**From:** Claire Booth  
**Sent:** 05 September 2012 13:05  
**To:** Jane Tucker  
**Subject:** FW: Consultation on planning application 3/2012/0639 Windy Hills Farm, Chipping  
**Attachments:** 12 0639 consult highways.pdf

**From:** Hornby, Mark [mailto:Mark.Hornby@lancashire.gov.uk]  
**Sent:** 05 September 2012 13:05  
**To:** Claire Booth  
**Cc:** ENV EPP Customer Service Area East  
**Subject:** FW: Consultation on planning application 3/2012/0639 Windy Hills Farm, Chipping

Please can we have your comments on the above planning application? It is for the proposed conversion of barn into two dwellings, creation of curtilages and installation of new package treatment plant. I have attached the formal consultation letter, but there are too many plans and documents to attach to an email, so here is a link to view the application on our website <http://www.ribblevalley.gov.uk/planningApplication?appNumber=3%2F2012%2F0639&submit=Go>

Location Plan

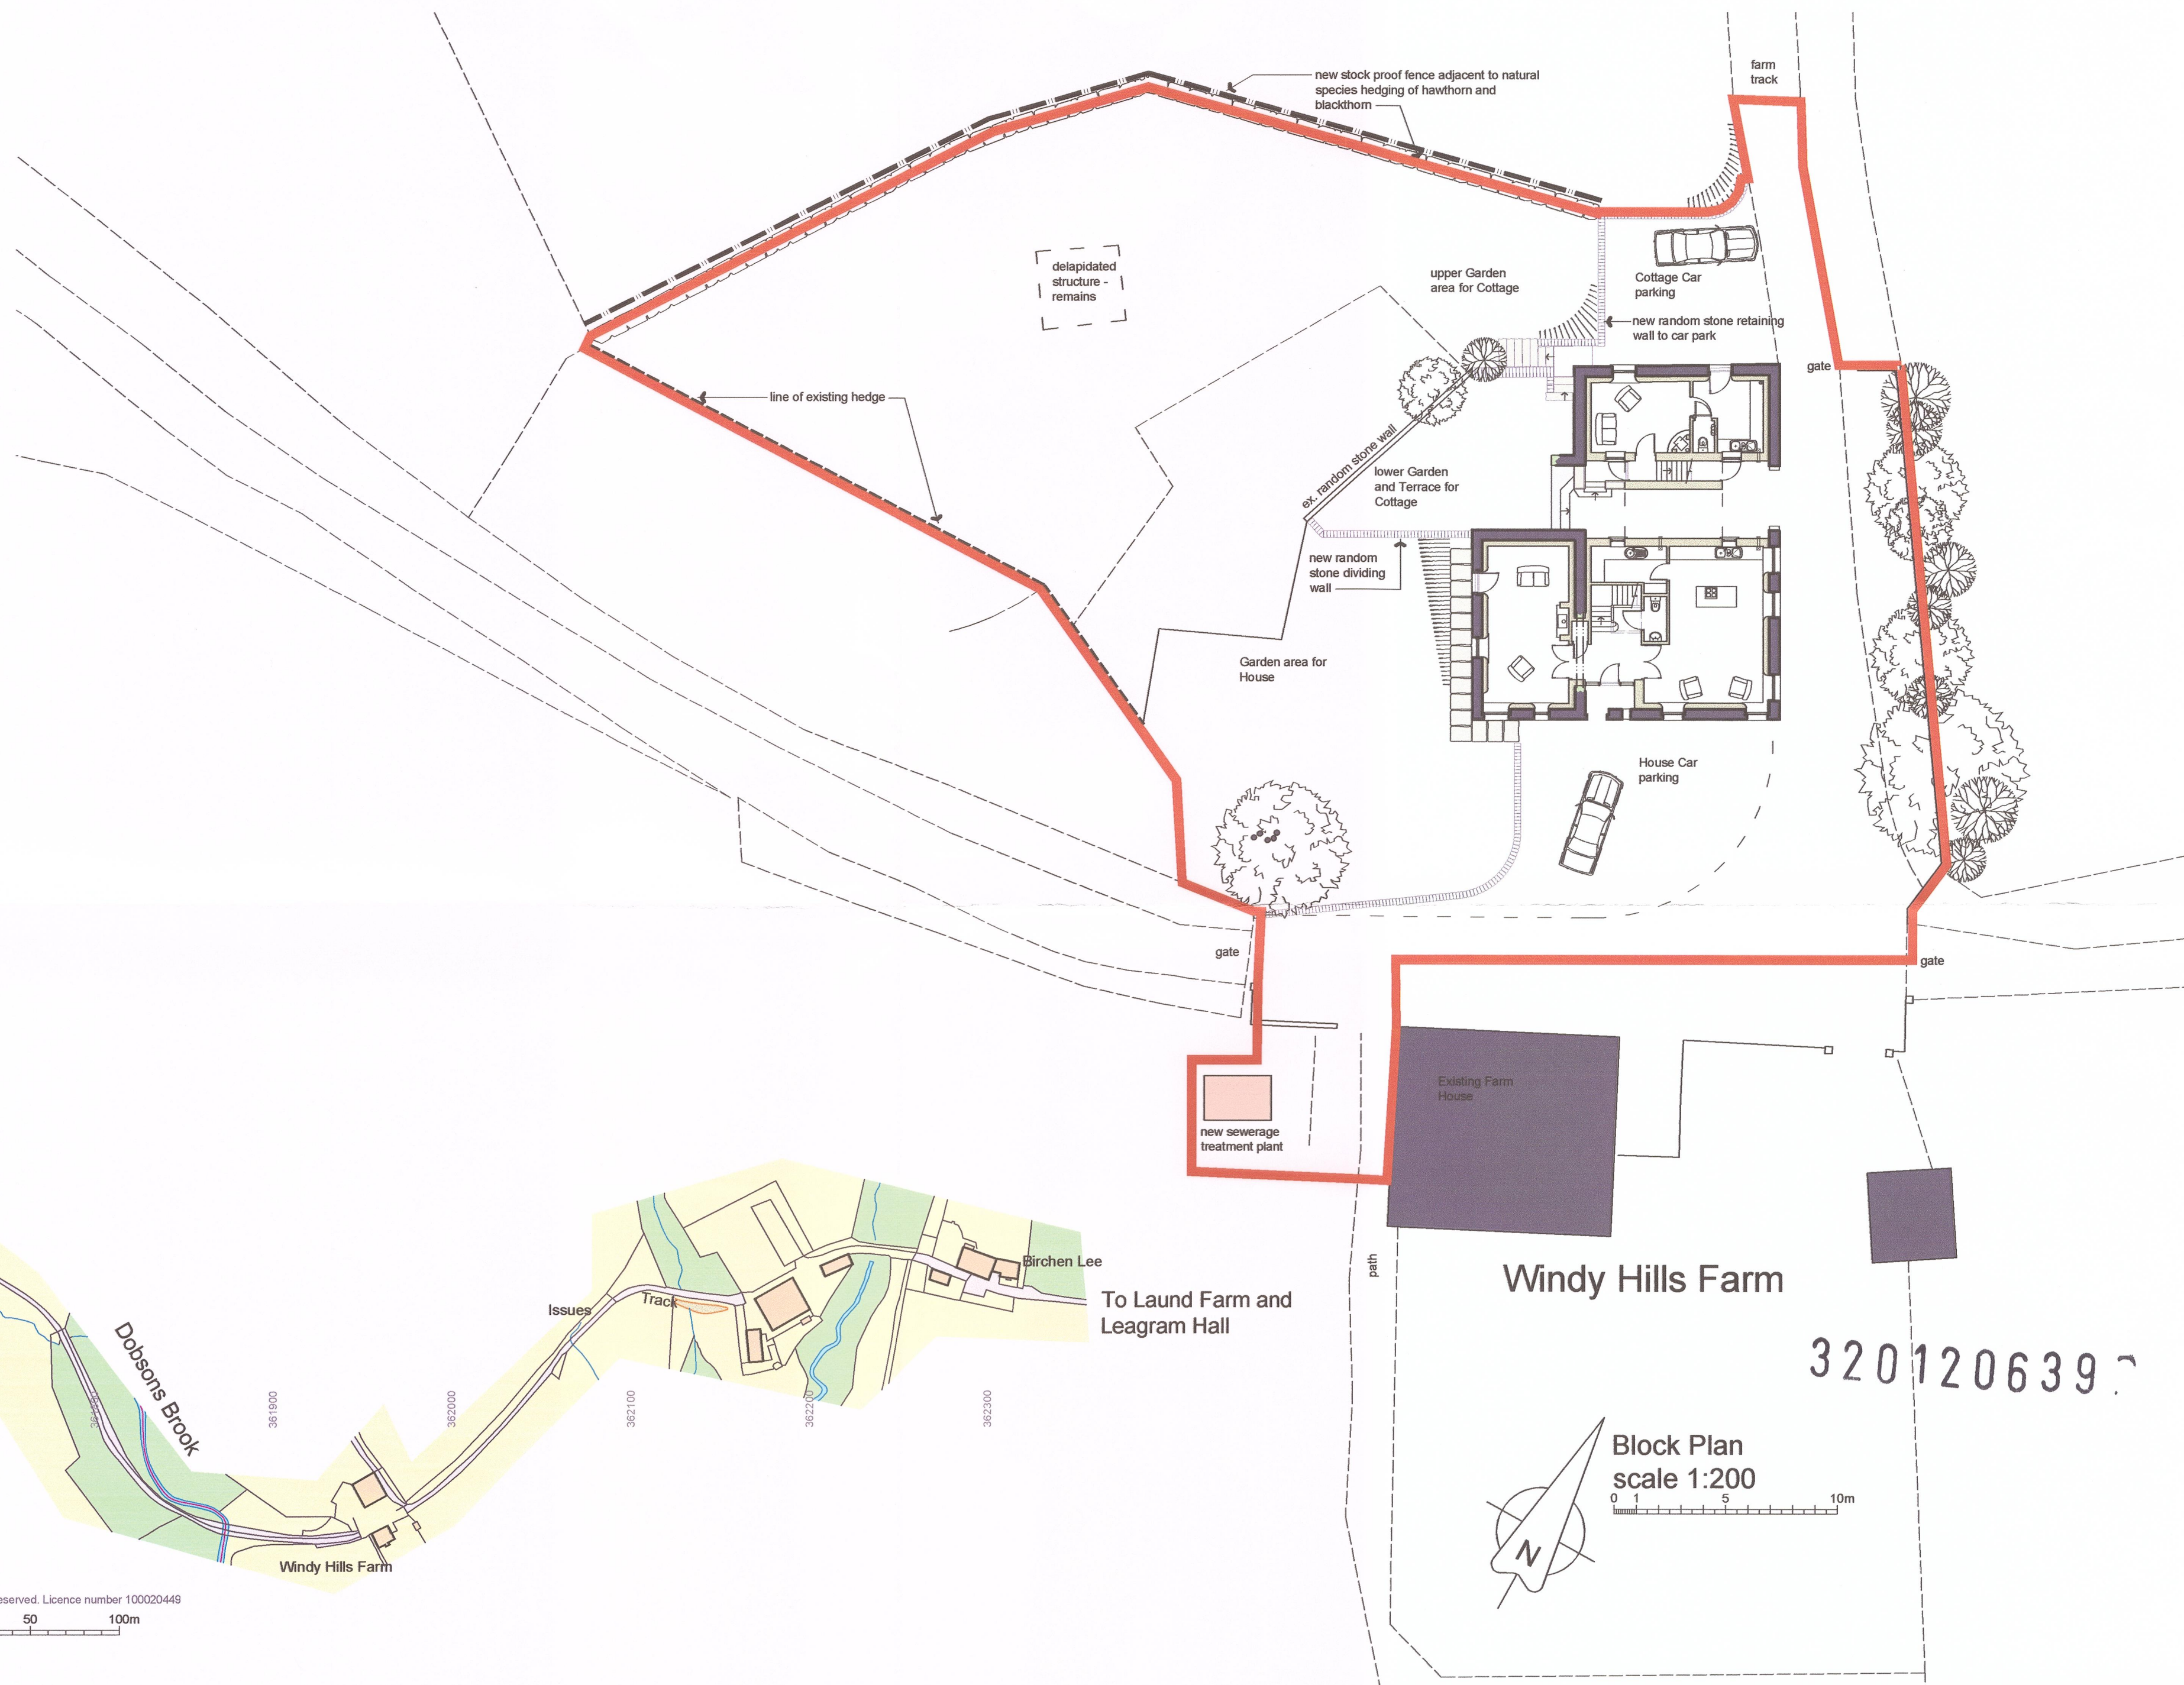
There are two possible access routes to the development site, both of which are along unadopted farm tracks. The route from the east is currently in use and is of a reasonable standard throughout for the likely traffic using it. The western route is in very poor condition and would require substantial improvements to the surface and several passing places to make it suitable for everyday use.

I therefore have no objection to this proposal, provided that the sole vehicular access to the site is via the eastern route.
